Application No: Y/146/20/RES
Site Address: Land at Street Buildings North End Road Yapton BN18 0DT
Description of works: Application for approval of reserved matters for the erection of 45 dwellings pursuant to Section 73 permission Y/13/18/PL (following the grant of outline planning permission Y/49/17/OUT) (resubmission following Y/39/20/RES). This application may affect the setting of a Listed Building.

Thank you for your internet representation made on 8th January 2021 which has been recorded as an objection with the comments as follows:

Title:
PLANNING LAYOUT

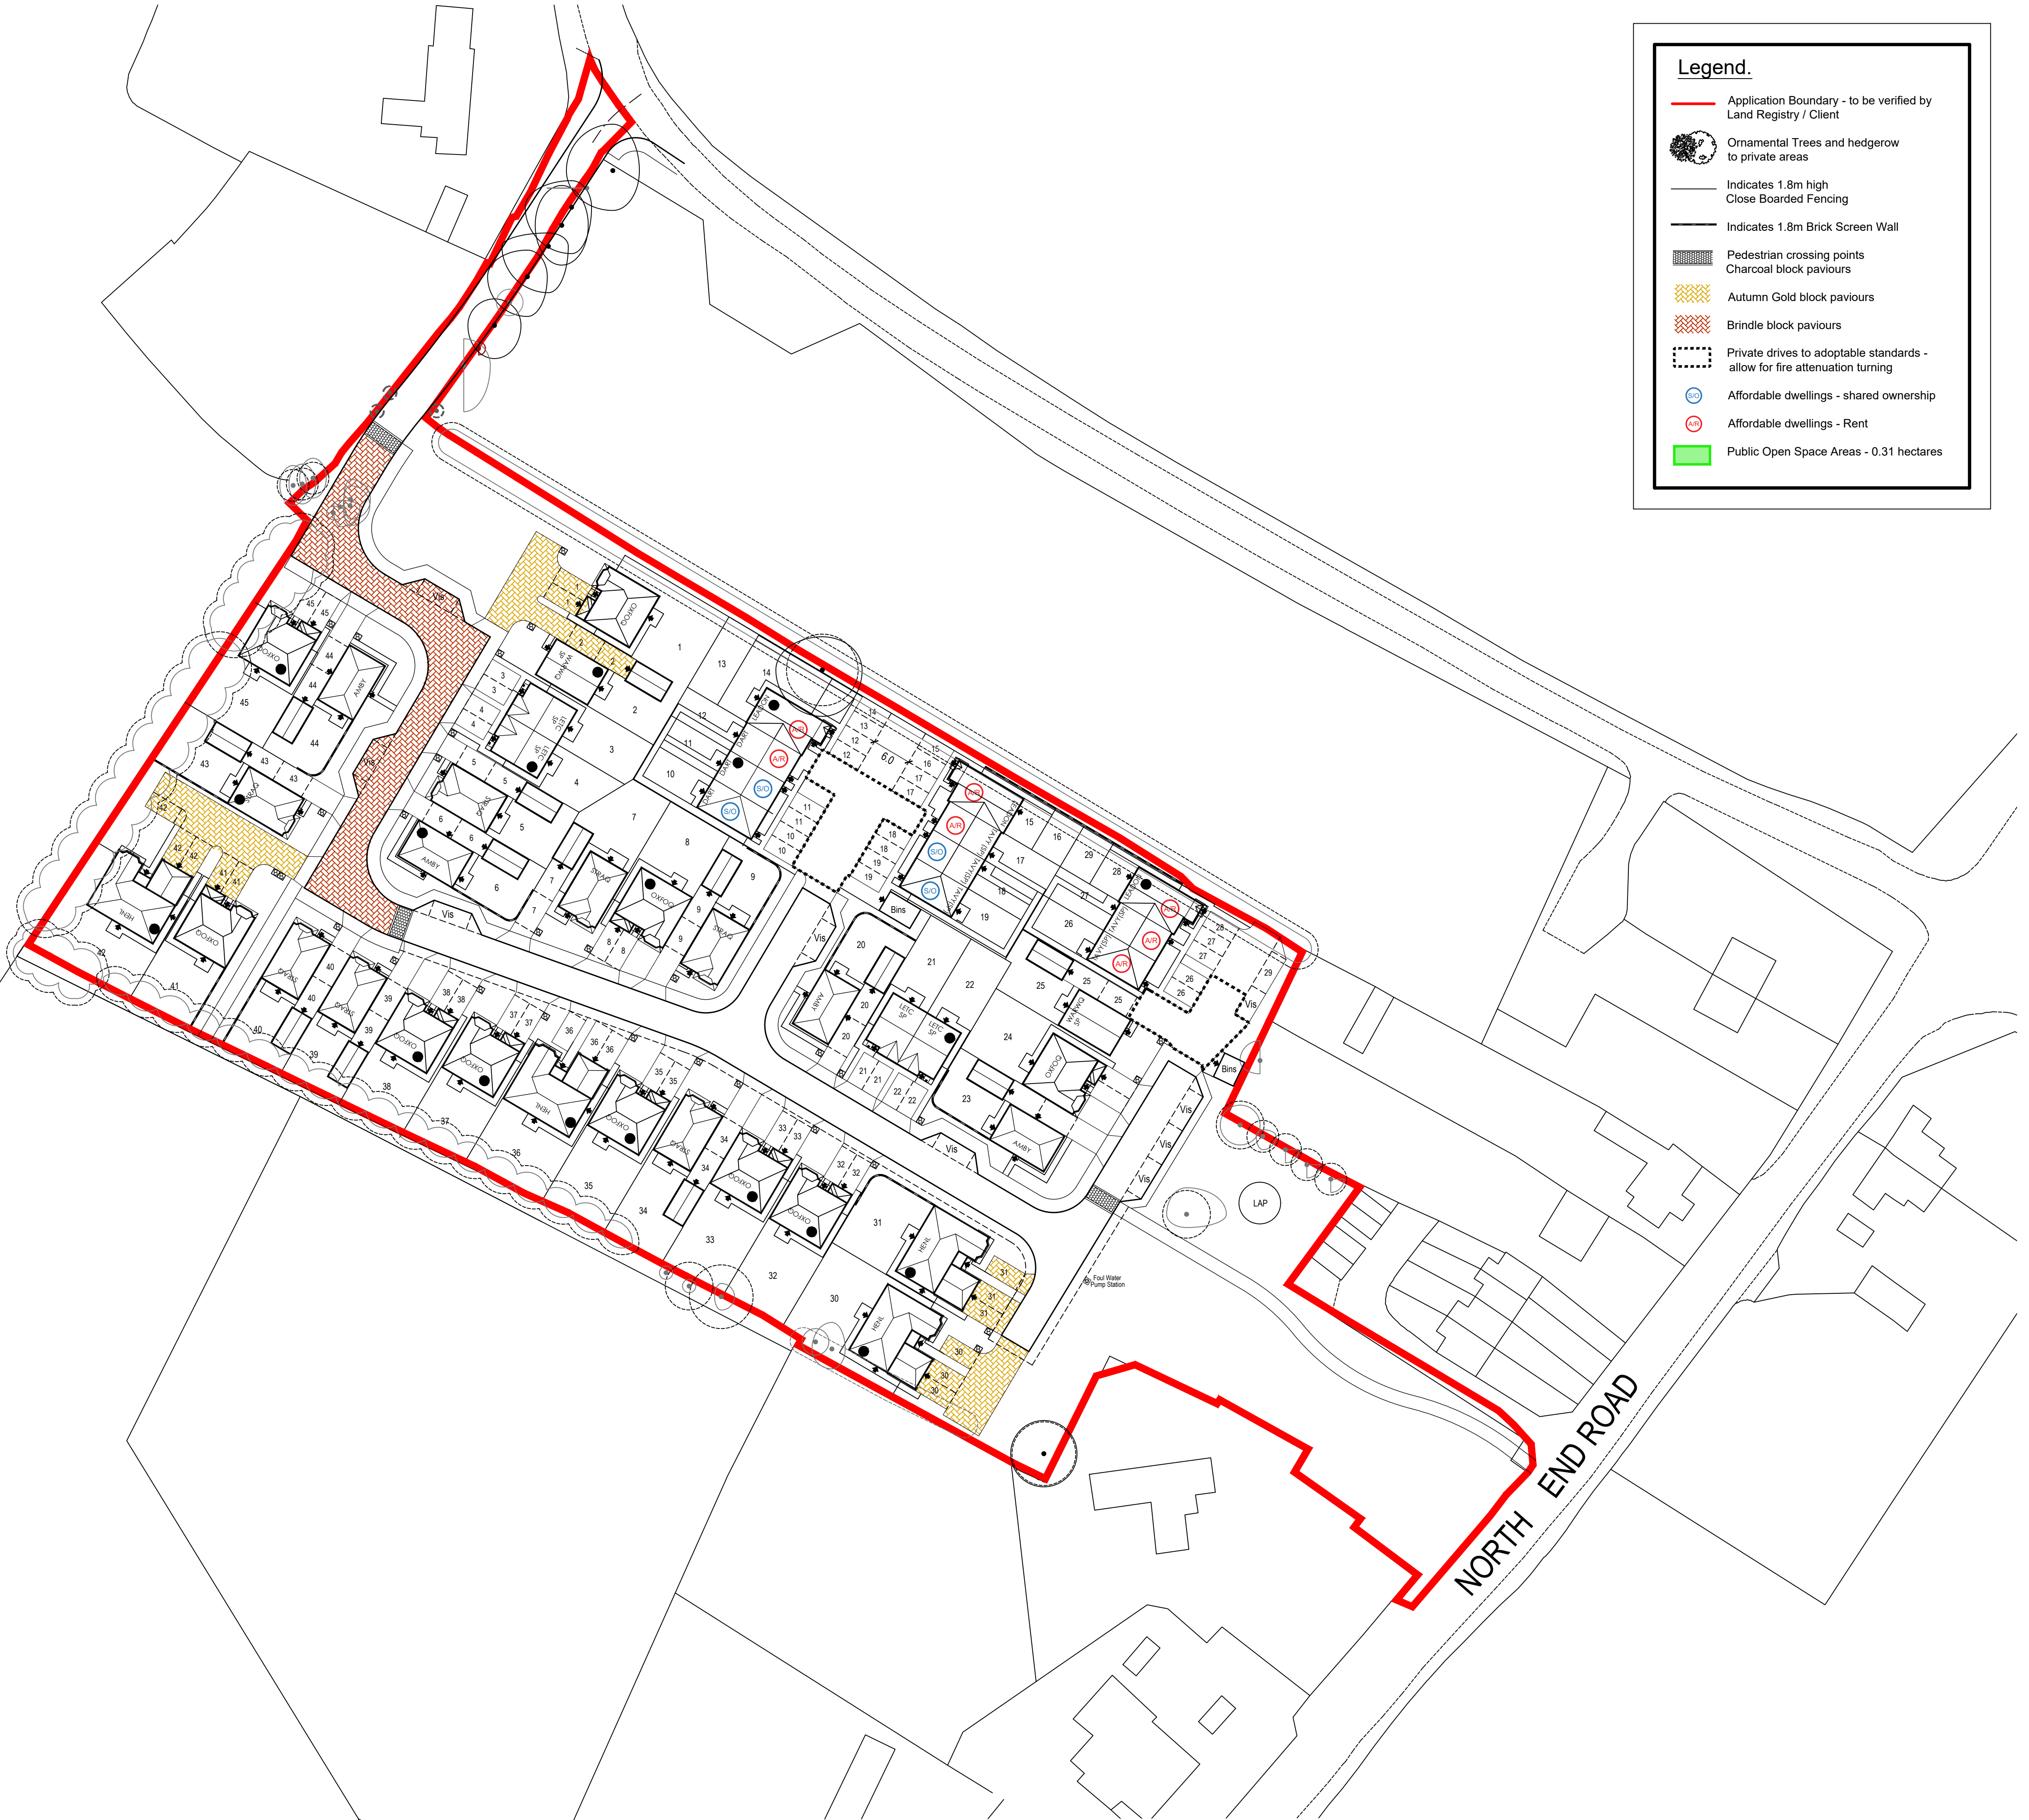
This site fails to support the creation of a north west yapton quadrant nmu pathway. The purpose and clear concept is that new housing estates support the above agenda which then impacts and helps support climate change by providing an alternative means of travel other than by car for all new residents. Currently this site shows a short stretch of route and then puts cyclists straight back on a main road

Similarly I can see no comment about how cycles will be stored on site and the site if well designed should ensure that Access to bikes is as simple as access to car
